Recommendation Report for Works to Tree(s) on trees subject to a Tree Preservation Order (TPO)

REF NO: FG/170/20/T

LOCATION: Verge opposite 18a Ocean Drive
The Poplars
Ferring
BN12 5GJ

PROPOSAL: Various works to 6 No. Austrian Pine trees.

Plan showing location of trees

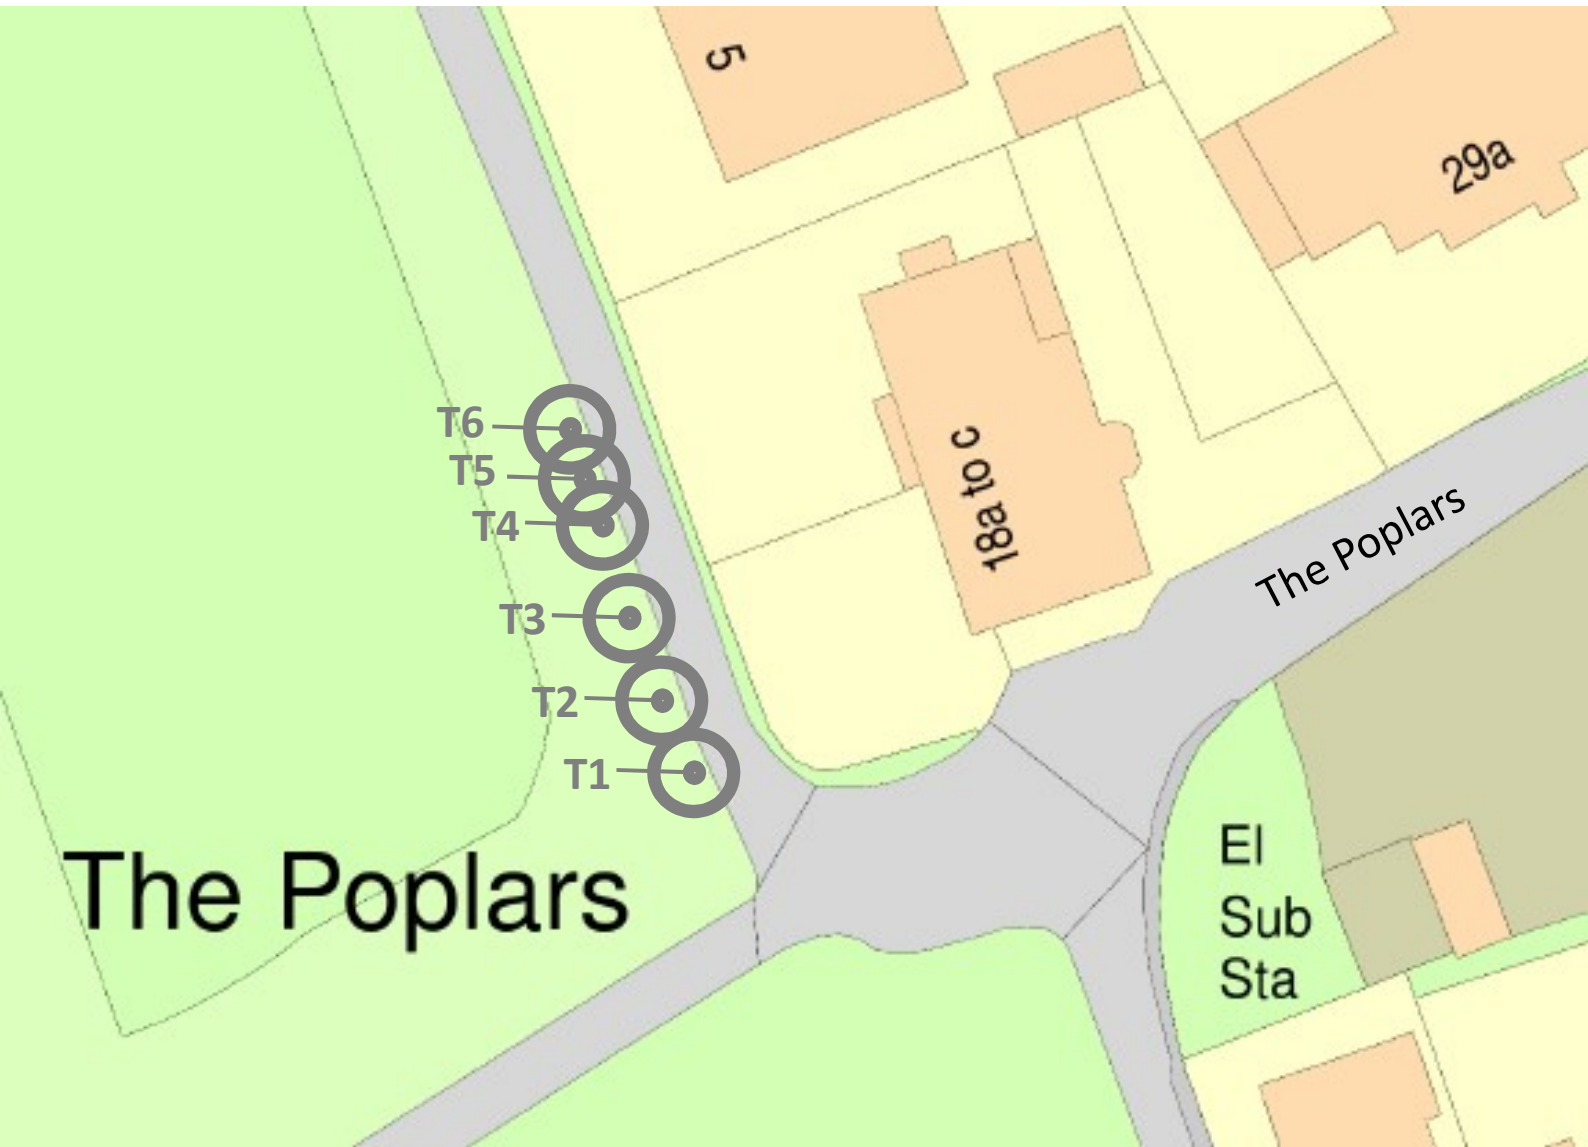
T1 & T2 - The bulk of property overhang arises from these trees. Crown lifting to 5m could pave the way for excessive reduction of lateral spread (to achieve the proposed overhead clearance), resulting in unacceptably large wounds being created. The stated reduction of lateral spread from 8m to 5m is excessive and likely to result in decline of individual branches.

T3 - There is no growth below 5m ht. or significant overhang from the tree's east aspect.

T4 & T6 - Both trees are heavily suppressed by their companions and not obvious candidates for the work proposed.

T5 - Low branches are present (below 5m ht.) and could be removed without detriment to the amenity value of this tree. Property overhang is proportionate and should remain.

The applicant proposes 2-3metre reduction of lateral spread for several trees. If the full extent of meterage is applied, that would exceed the recommendations in British Standard 3998:2010 - Tree Work and cause decline in some of those limbs/branches.

T1 & T2 - Reduce radial spread by no more than 1.5m. In any event, a minimum of 6.5 metres lateral spread when measured from the main stem must remain. Crown lift by removal of/reducing small diameter branches (<100mm) to achieve a maximum of 4metres overhead clearance.

T5 - Crown lift by removal of/reducing small diameter branches (<100mm) to achieve a maximum of 5metres overhead clearance.
